Consultation Response from: KC Environmental Health (Pollution & Noise Control)		
2025/92776 land at Eastfield, Shepley, Huddersfield, HD8 8HB		
Outline application, with all matters reserved, for residential development with associated open space, landscaping, drainage infrastructure and associated works		
Responding Date: 5th December 2025	Responding Officer: SR–Air Quality & Contaminated Land MN- Noise	Responding Ref: WK202535458
<p><u>Comments</u> The application form identifies a development of residential dwellings on land described as an agricultural use. The site is situated east of Shepley Village and generally falls in a northeasterly direction.</p> <p><u>Contaminated Land</u> We are aware that a Hydrogeological Impact Assessment / WSP-UK0042720-WATER-REPORT-DOC-0001 rev. V5, has been submitted in support of the application; this is outside the remit of Environmental Health, the Planning Officer is advised to seek the comments of other consultees.</p> <p>In support of the application a Geoenvironmental Preliminary Investigation by RWO Associates, dated August 2025, ref: KR/GEODS/G25025 has been submitted. The report contains geotechnical information which is beyond the re

Key:	Living Room Outline Mitigation:
—	Rw+Ctr 27dB (4/12/4mm) glazing; Mechanical Ventilation with Heat Recovery
Unmarked facades have no specific requirements

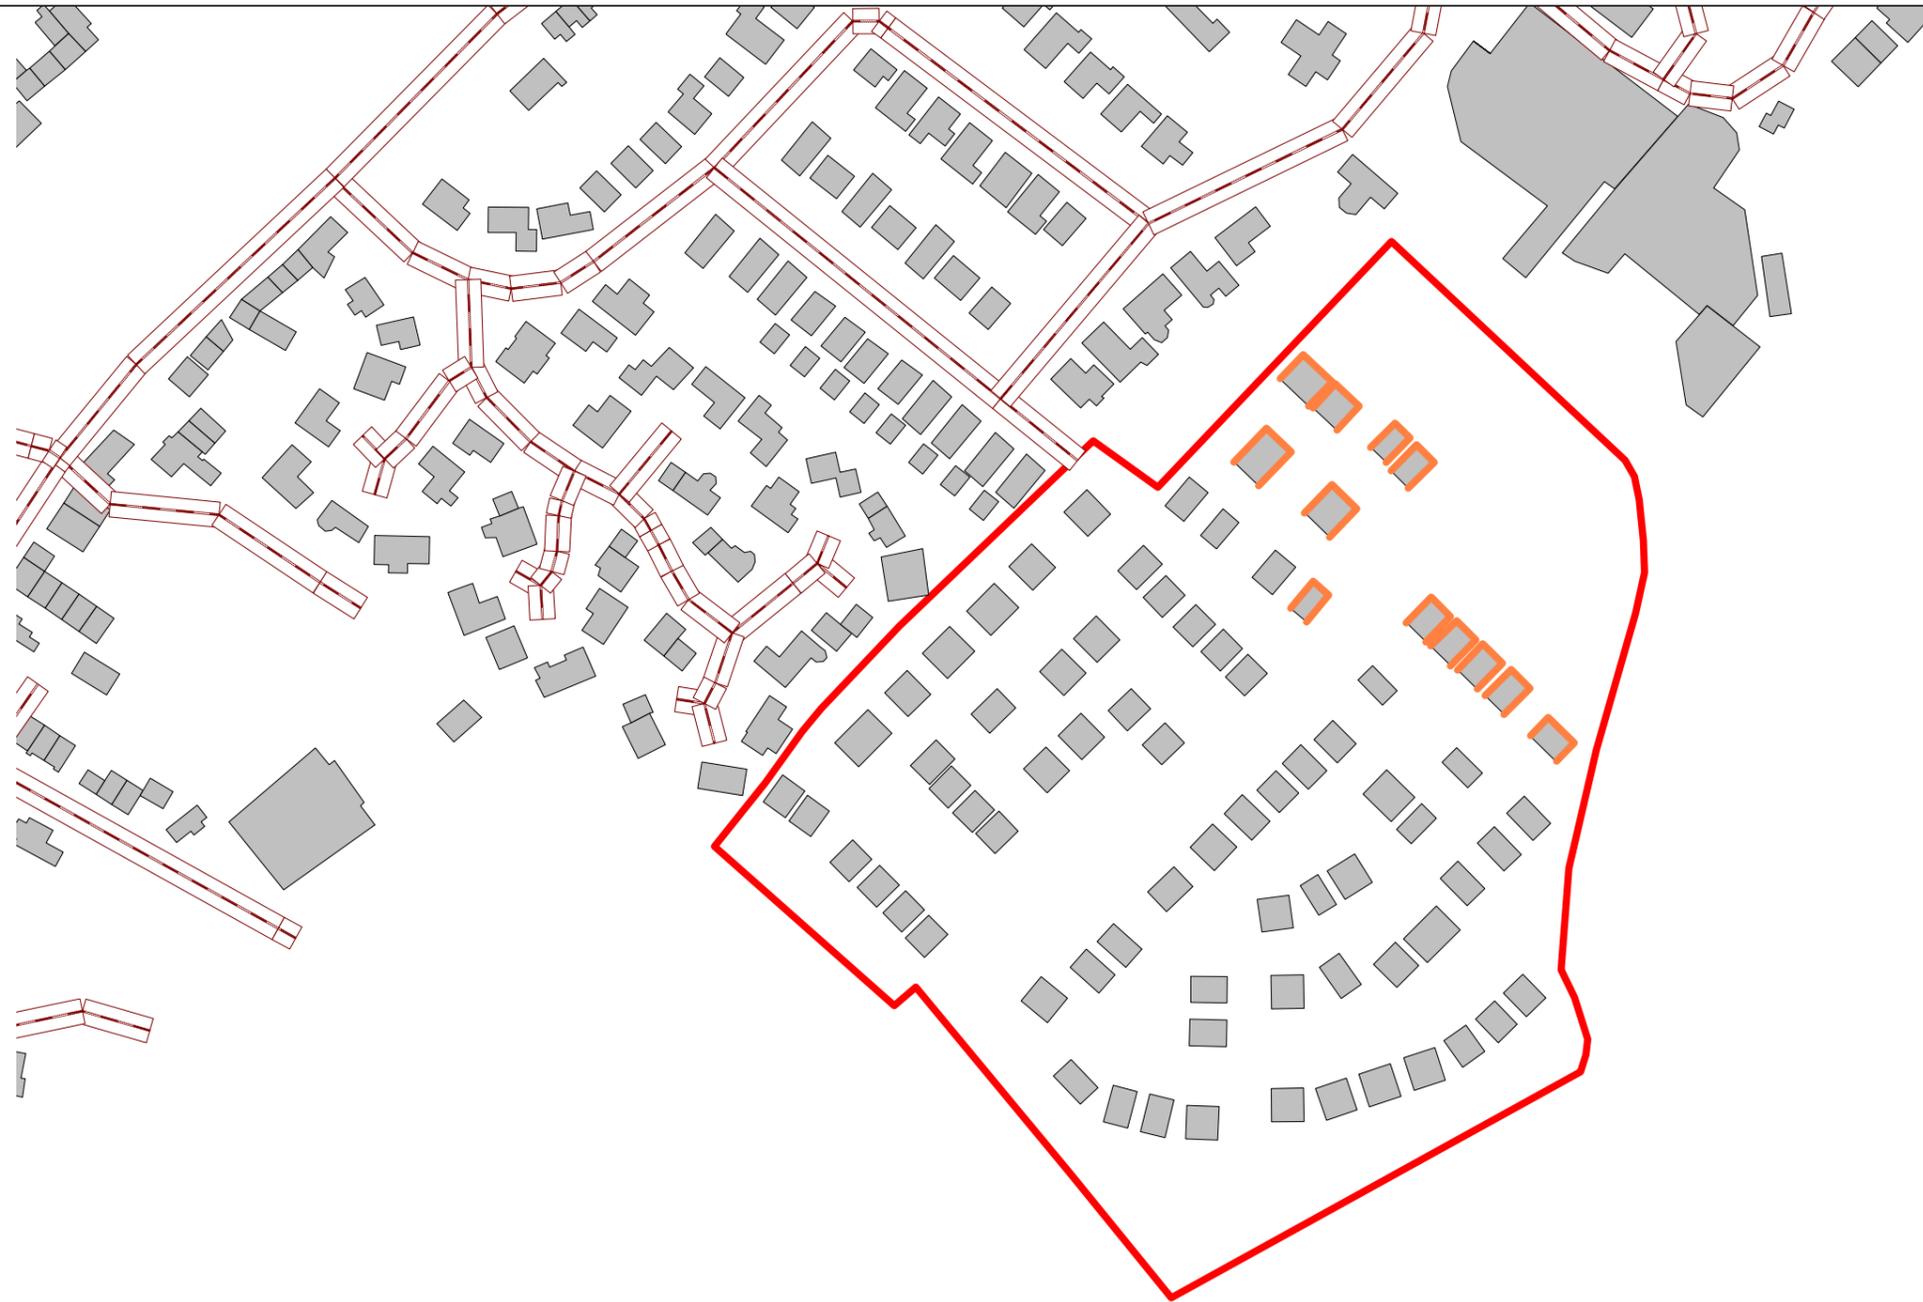
The author states that following discussion with the applicant, changes to the layout were implemented as reflected in drawings 5 and 6 to ensure appropriate noise levels are achieved across the development site. Glazing and mechanical ventilation with heat recovery is recommended as per the specification in table 11 and this is only applicable to the north of the site and is reflected in figure 4 (daytime) and figure 5 (nighttime). Externally, no mitigation is recommended as stated in para 7.1.3.

We accept the initial Noise Assessment but as this is an outline application, due to the noise from the north of the site, would need assurances the layout and recommended mitigation measures remain at the reserved matters stage. Any changes will require the submission of a further/addendum noise assessment and a condition is recommended to cover this possibility.

NC9 Noise Assessment Report and Mitigation Scheme - Condition

Before construction work commences, a report specifying the measures to be taken to protect the development from noise from all significant noise sources that are likely to affect the proposed development shall be submitted to and approved in writing by the Local Planning Authority. The report shall:

- a) Determine the existing noise climate
- b) Predict the noise climate in living rooms and gardens (daytime), bedrooms (night-time) and other habitable rooms of the development
- c) Detail the proposed attenuation/design necessary to protect the amenity of the occupants of the new residences (including ventilation if required).
